### M3 JUNCTION 9 NATIONALLY SIGNIFICANT INFRASTRUCTURE PROJECT

Examining Authority First Written Questions – Response 15<sup>th</sup> June 2023

**Winchester**  
City Council

DRAWING TITLE
 FIGURE 7.4 - LANDSCAPE AND VISUAL: VIEW LOCATIONS
 APPF REGULATIONS 5(2)(a)
 DOCUMENT REFERENCE 6.2

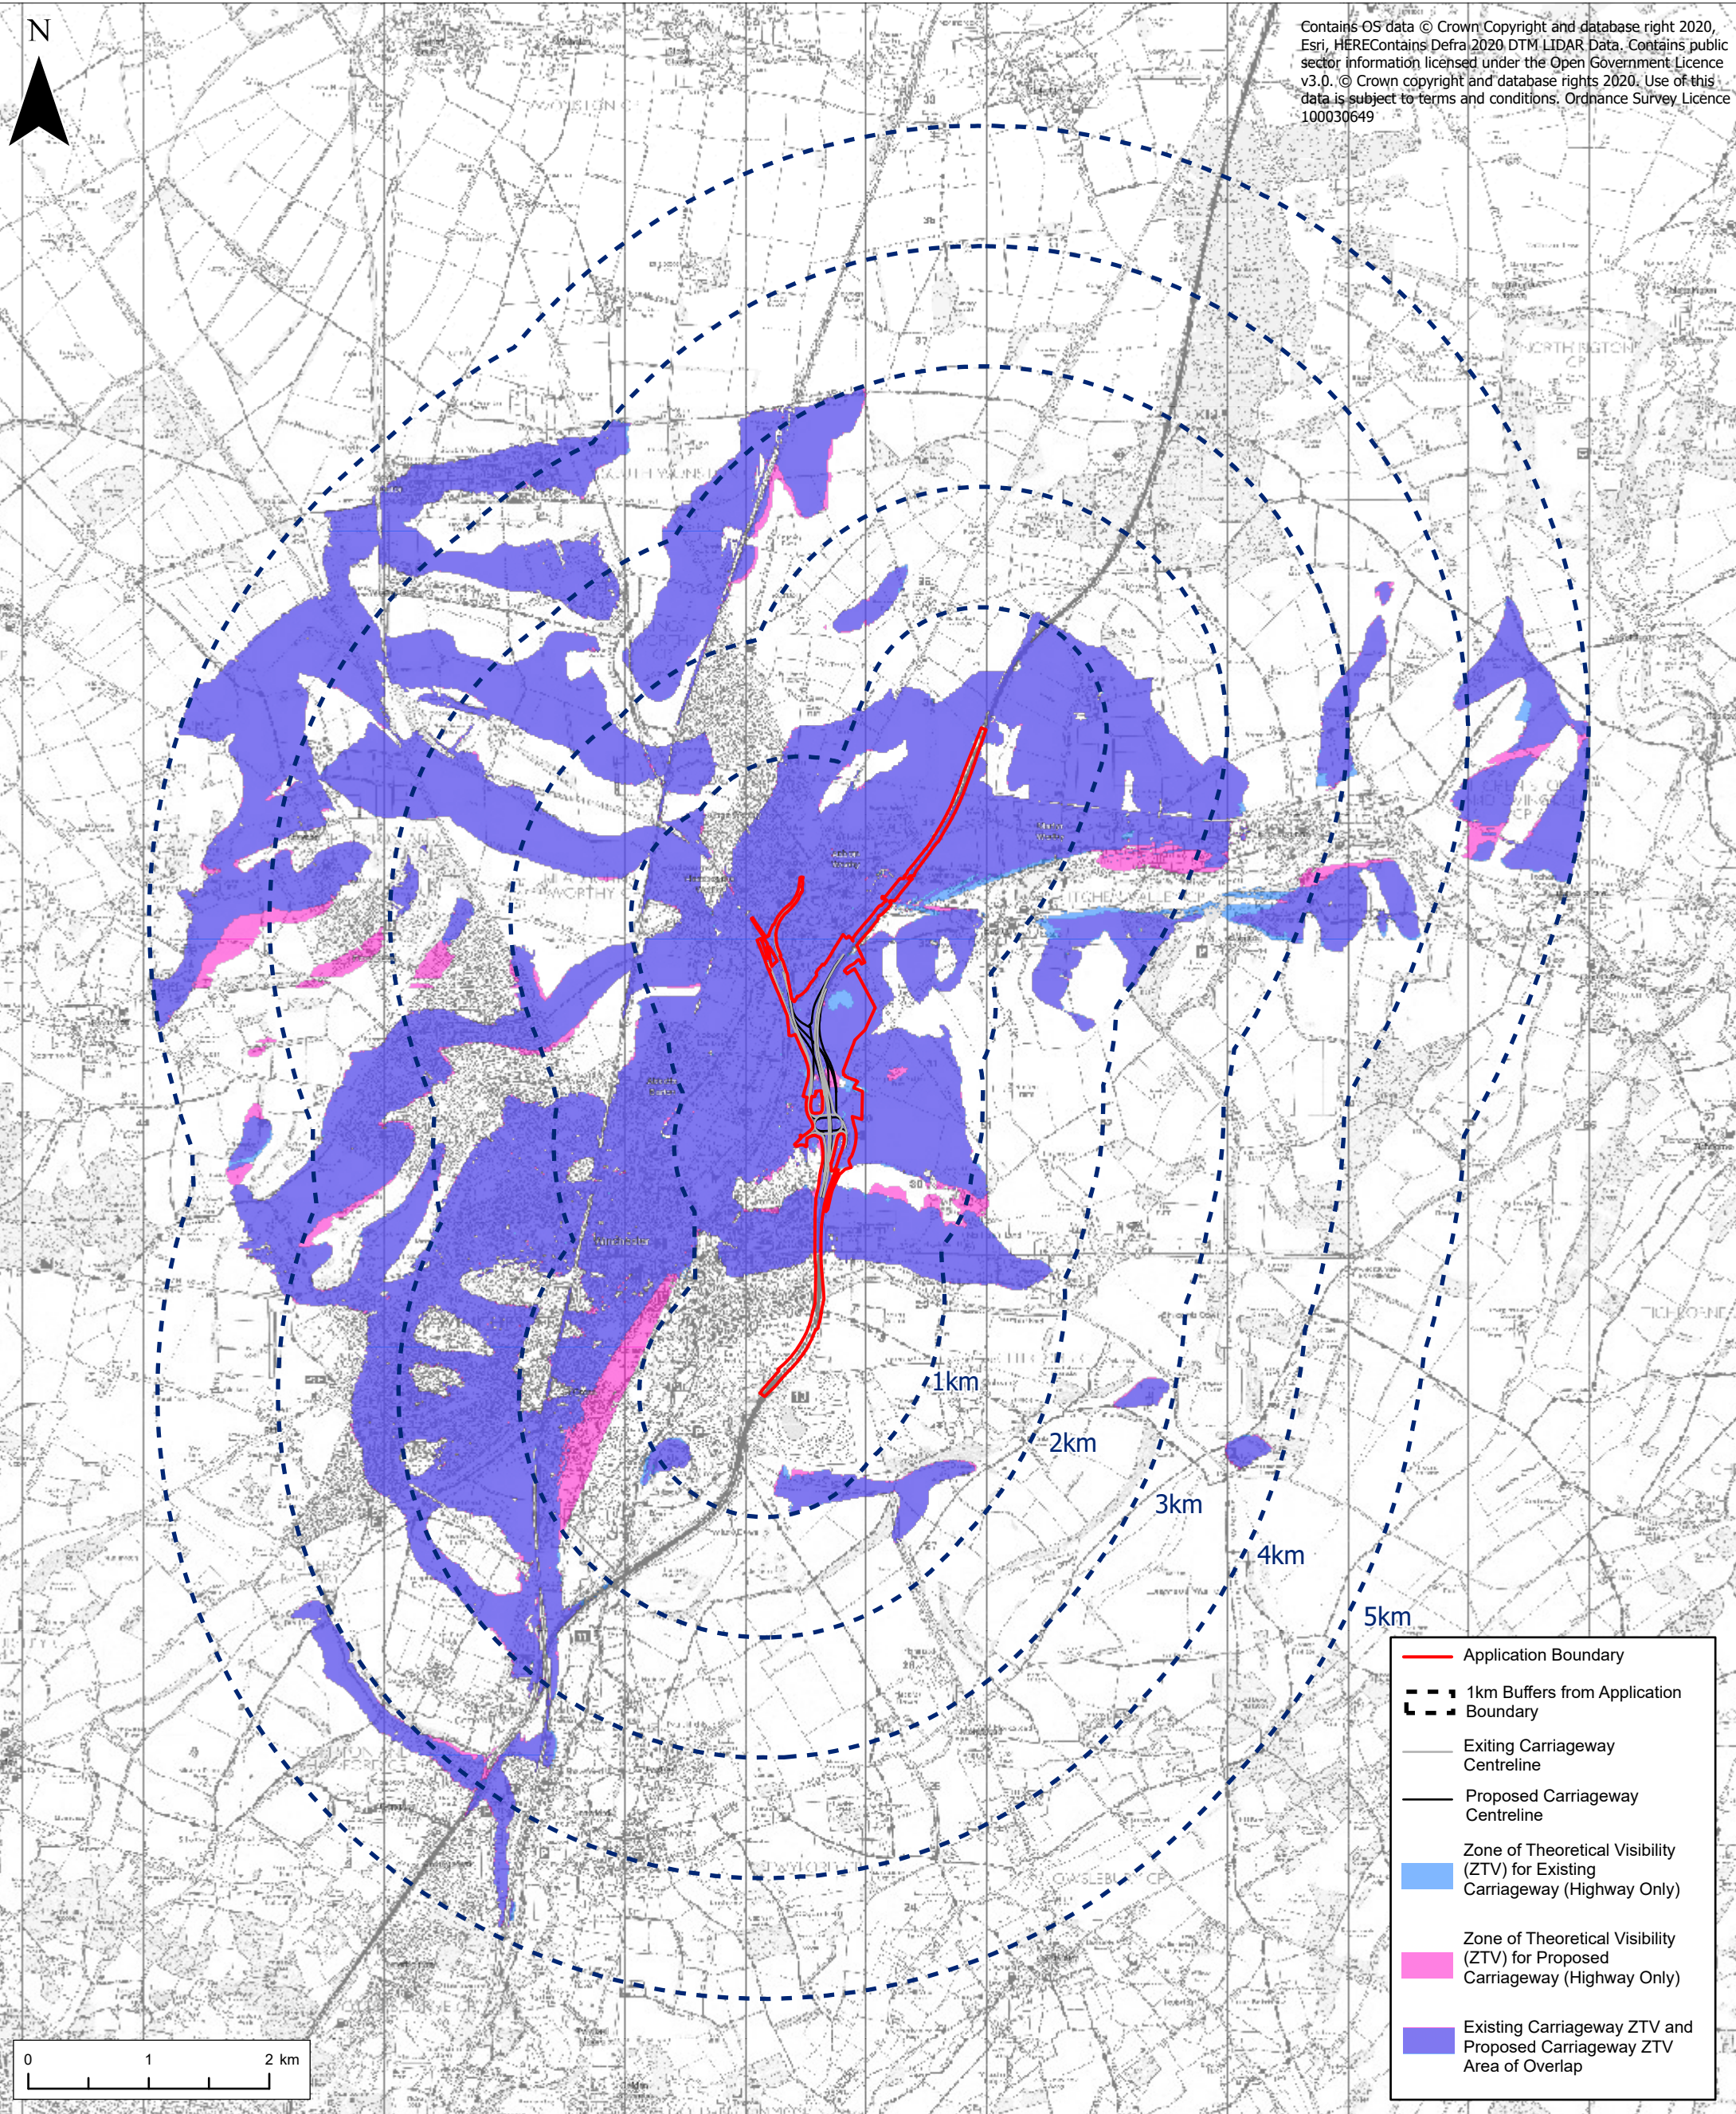
Q12.1.22	The ES Chapter 7 Landscape and Visual [APP-048] presents the findings of the assessment of the construction and operation of the proposed development. <ul style="list-style-type: none"> <li>• Are you content with the assessment methodology and the recording of baseline information in the Landscape and Visual Impact Assessment (LVIA) and the approach to the LVIA assessment?</li> <li>• Do you have observations on the limits of deviation proposed in the scheme?</li> <li>• Are you content with the detailed mitigation measures in relation to landscape impact and visual effects set out in the REAC Tables of the fiEMP [APP-156] including whether they have been drafted with sufficient precision to ensure enforceability? For example, LV13 in relation to earthworks, LV18 in</li> </ul>	<ul style="list-style-type: none"> <li>• Yes the methodology and baseline info approach is acceptable</li> <li>• No observations.</li> <li>• Table 3.2 G1 – Landscape Clerk of Works to be appointed LV1 – winter and summer surveys required LV9 – query whether rabbit fencing around areas of seedling/whip planting been considered as alternative to guards. LV10 – further details on compounds required LV13 – further details on earthworks required</li> </ul>

<p>relation to the creation of chalk grassland and LV20 in respect of ongoing management and maintenance.</p> <ul style="list-style-type: none"> <li>• Are you satisfied with the presentation of baseline photographs and visualisations prepared for the scheme?</li> <li>• Are you satisfied with the approach adopted by the Applicant in relation to the night-time assessment of lighting on landscape and visual receptors?</li> <li>• What, if any, further mitigation is considered necessary and how should such measures be secured? For example, should the Draft DCO include a specific reference to the OLEMP/LEMP to secure all relevant mitigation referred to in the ES?</li> </ul>	<p>LV18 – regrading the existing topography to accommodate a cut for the road will effect the landscape  LV19 – drainage features are proposed in areas uncharacteristic of the landscape character. They are artificially too steep on their slopes  LV20 – noted as a repeat of LV22</p> <ul style="list-style-type: none"> <li>• Yes</li> <li>• Yes</li> <li>• Wider swaths of planting of at least 25m in depth should be provided along the SDNP edge of the M3 for screening and tranquillity with planting also at the top of slopes. The draft DCO must include specific references to any landscape and environmental document that refers to mitigation</li> </ul>
